**WEST SUSSEX COUNTY COUNCIL
STRATEGIC PLANNING CONSULTATION**

SUBJECT: BR/303/11/A - 1 x internally illuminated fascia sign & 1 x externally illuminated hanging sign.

Holland & Barrett, 17, London Road, Bognor Regis, West Sussex, PO21 1PQ

PROPOSED SECTION & PROJECTING SIGNAGE DETAILS
SCALE 1:20 @ A3

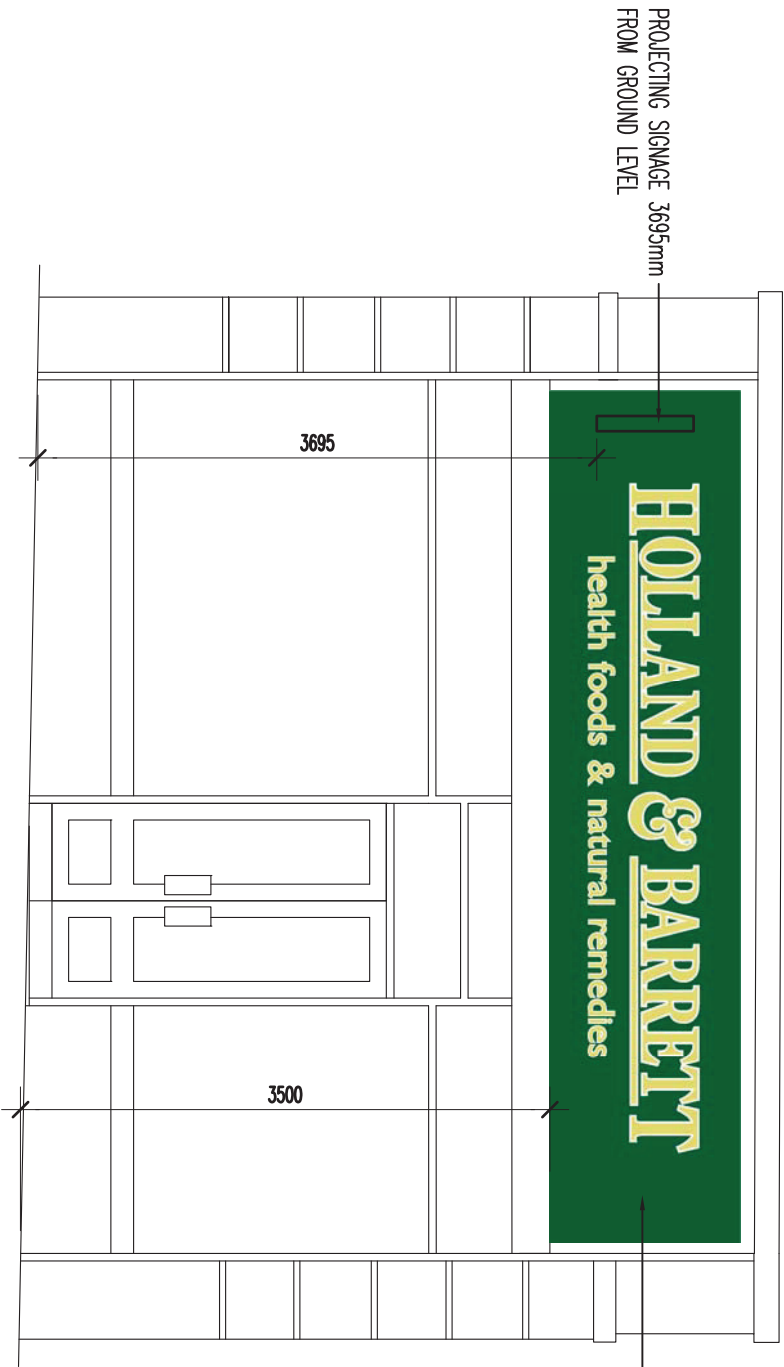
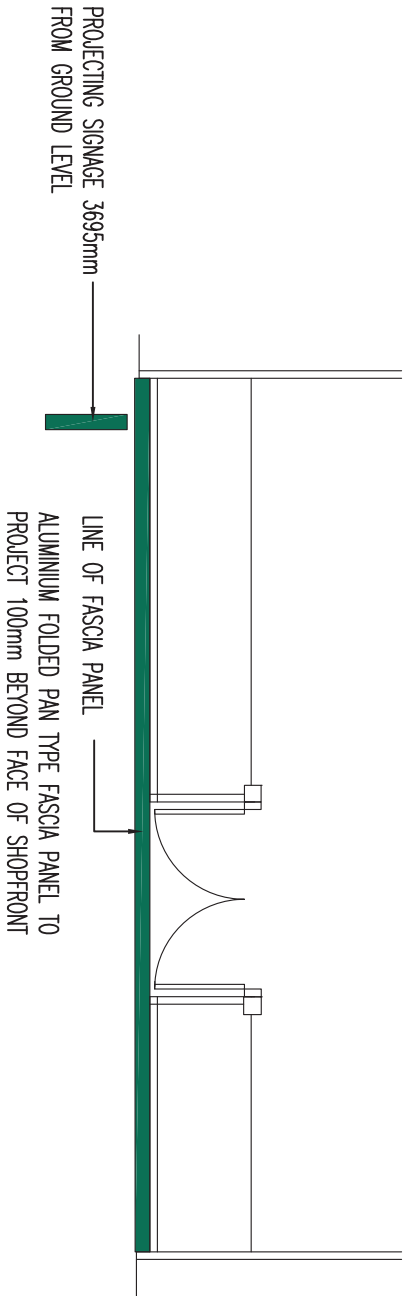
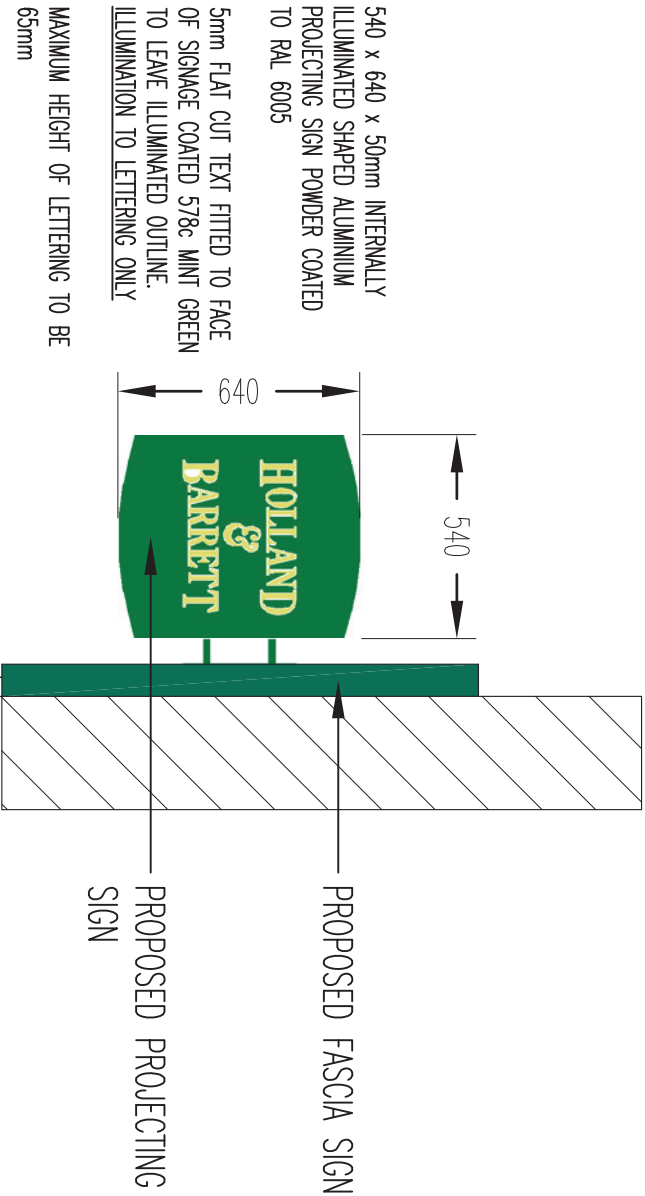
Upon inspection of the plans, it does not appear that these signs will be situated in locations where they could obstruct the highway. The proposed projecting sign will require a Section 177 Licence as it overhangs the public highway.

Provisionally, there would be no highway objection to these signs, providing they do not exceed 800cd/m².

Before the commencement of any operation, the applicant is advised to contact West Sussex County Council (Tel no: 01243 642105) to obtain a Section 177 Licence under the Highways Act 1980 to cover any structure that overhangs the highway.
